A303 Sparkford to Ilchester Dualling Scheme TR010036

8.18 Statement of Common Ground with Mr and Mrs A Walton, Long Hazel Park

STATEMENT OF COMMON GROUND

This Statement of Common Ground has been prepared and agreed by (1) Highways England Company Limited and (2) Mr and Mrs A Walton, Long Hazel Park

LA10, 18 HR [dB] NOISE LEVELS

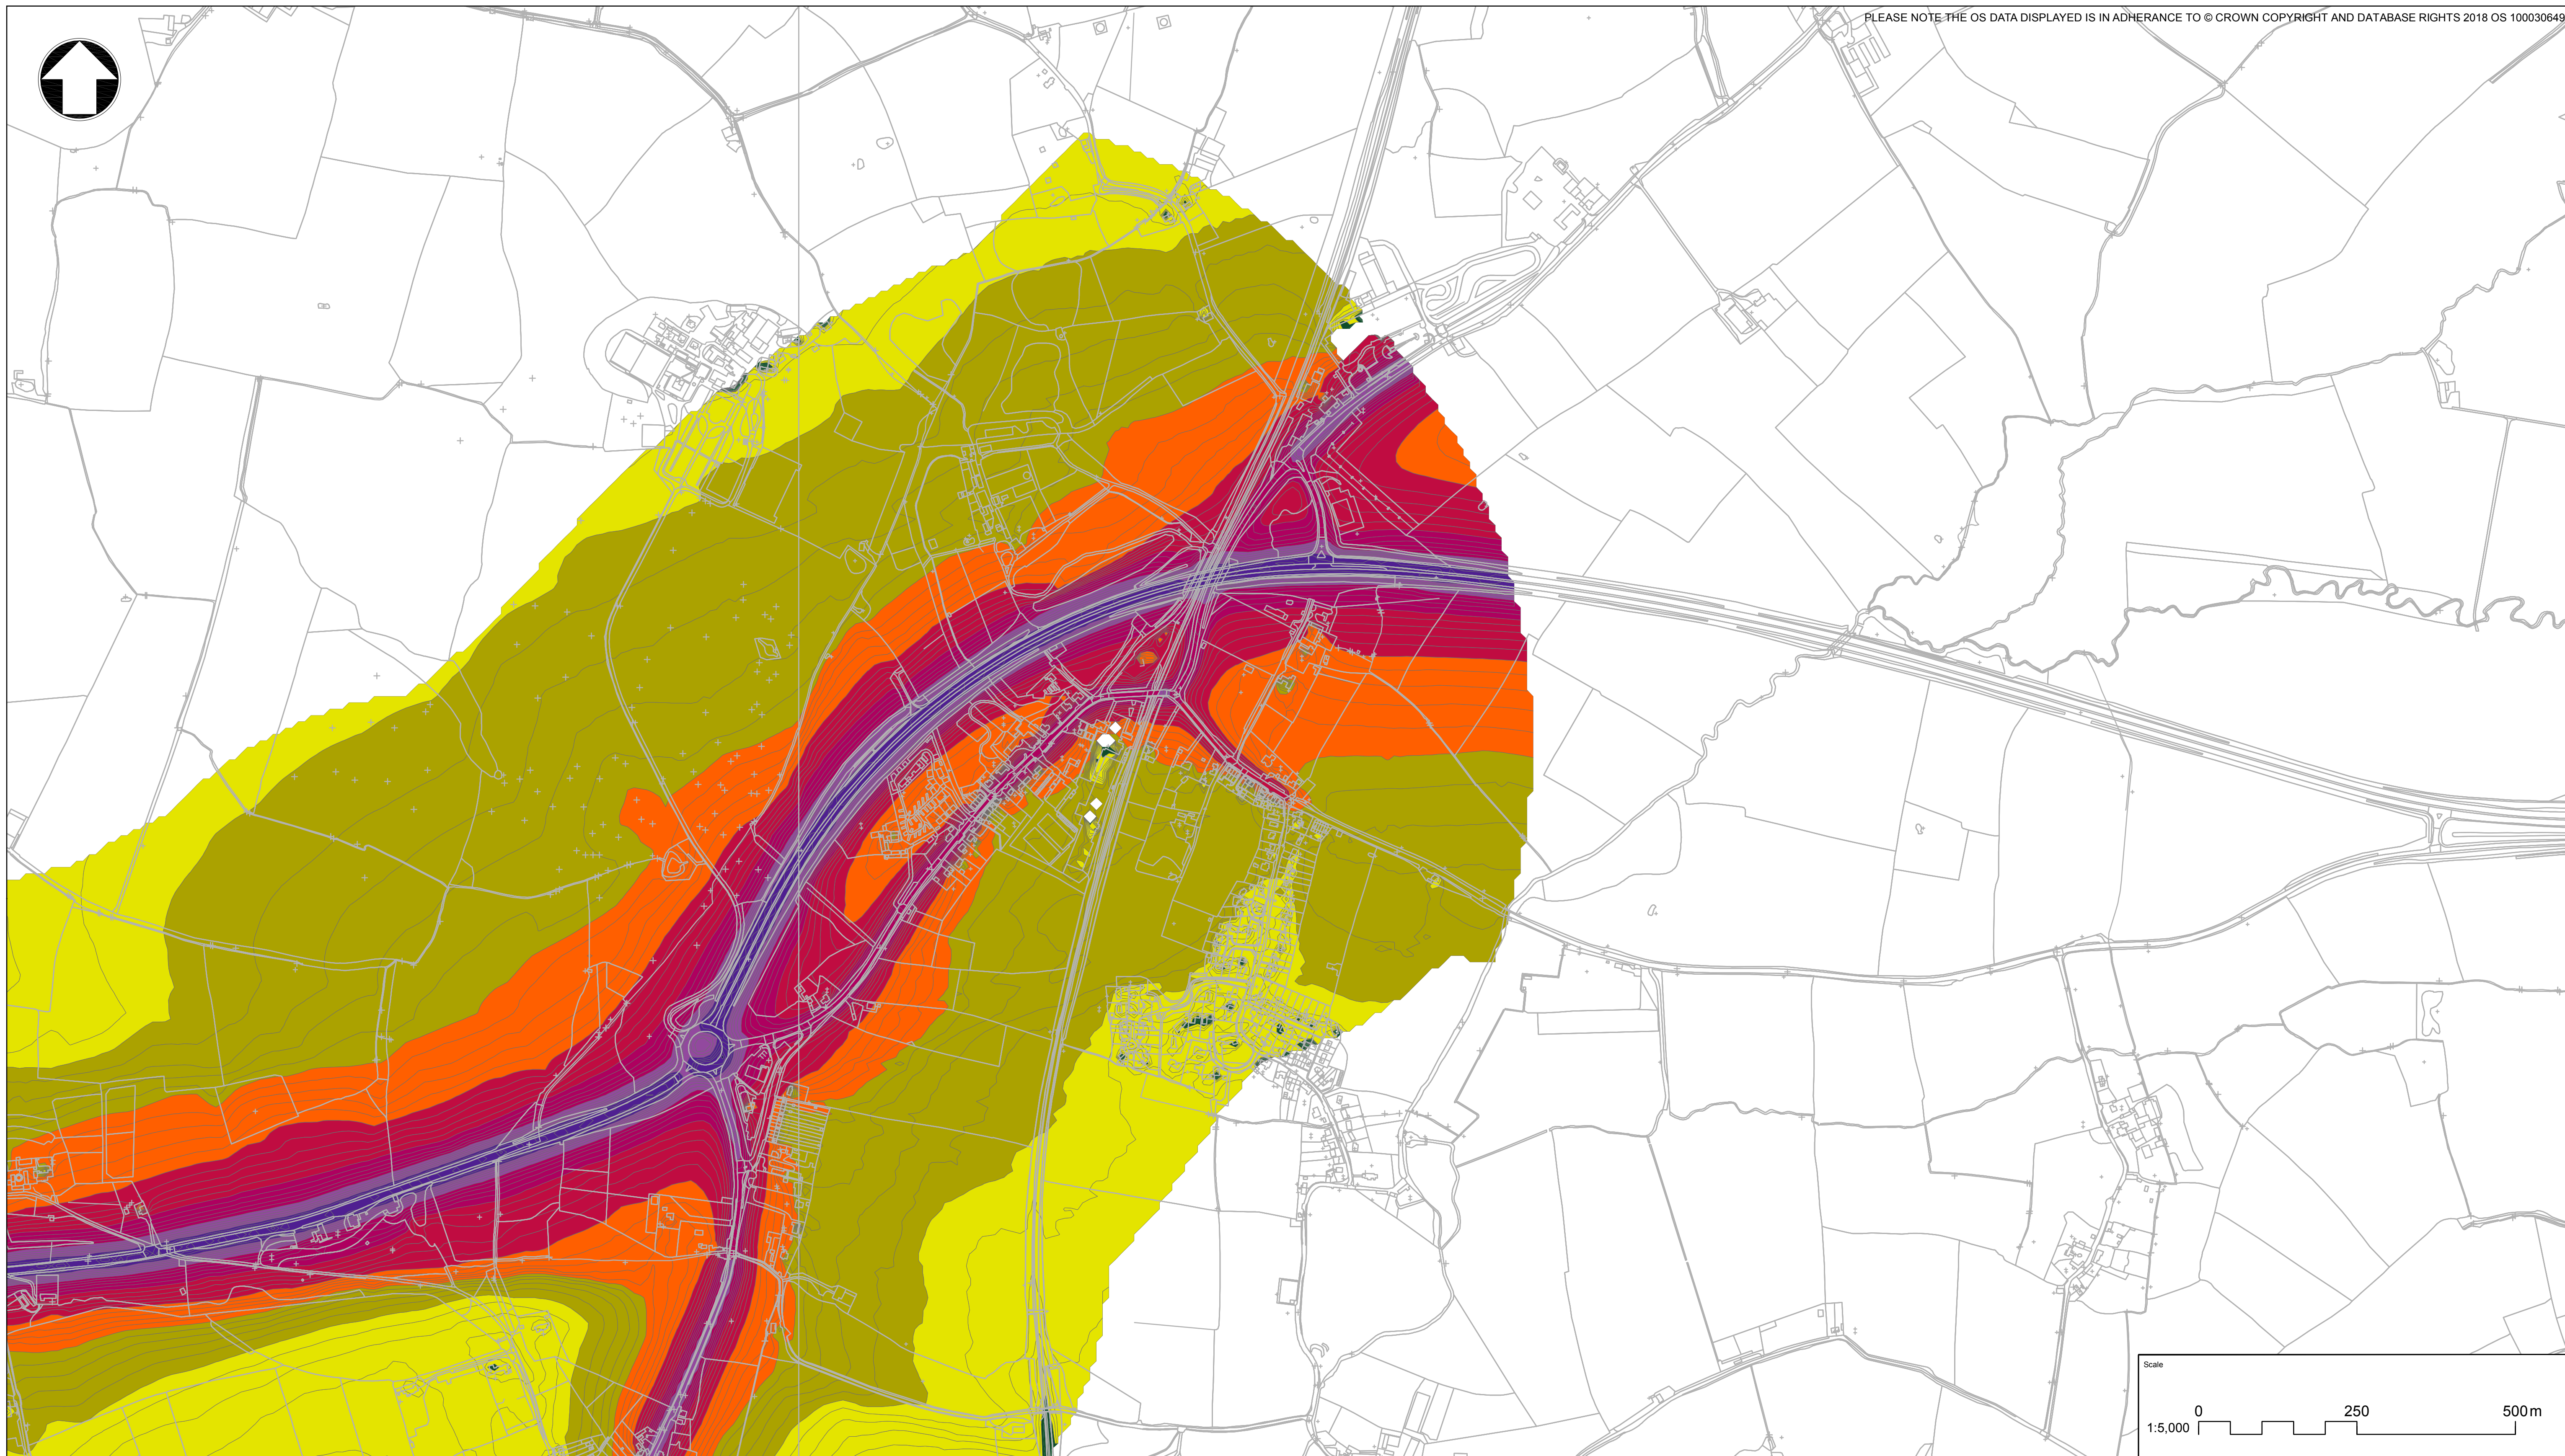
Noise predictions	In email correspondence, Highways England indicate that they estimate current traffic noise levels at	The predictions are based on a CadnaA noise model that implements details of the				AGREED

Topic	Mr and Mrs Walton's comment	Highways England response	Status
	<p>'Longhazel Caravan Park' to be 59.3 dB LA10 (18hr). They predict an increase of 2.2 dB in the short-term and 3.3dB in the long-term. This assessment is based on distances to AddressBase data points and not to property/land boundaries. So some lodges on the site might suffer greater exposure.</p> <p>Therefore, it would appear that by "Design Year", noise levels would have increased to around 62.6 dB LA10 (18hr).</p>	<p>topography, vertical and horizontal alignment, flows, road surfaces and many other factors and not just distances. The reported level was for the OS database receptor within the caravan park which is the home of Mr and Mrs Walton. It is correct that some lodges on the site are exposed to higher noise levels than Mr and Mrs Walton's home but none are exposed above the SOAEL in either the DM or DS cases in either the opening year or the design year (2038). The level of 62.6dB is the level at 4m (corresponding to first floor window) and for which a façade value correction of +2.5dB has been applied to account for sound reflection from the building. The level at the ground floor and without the façade correction would be lower.</p>
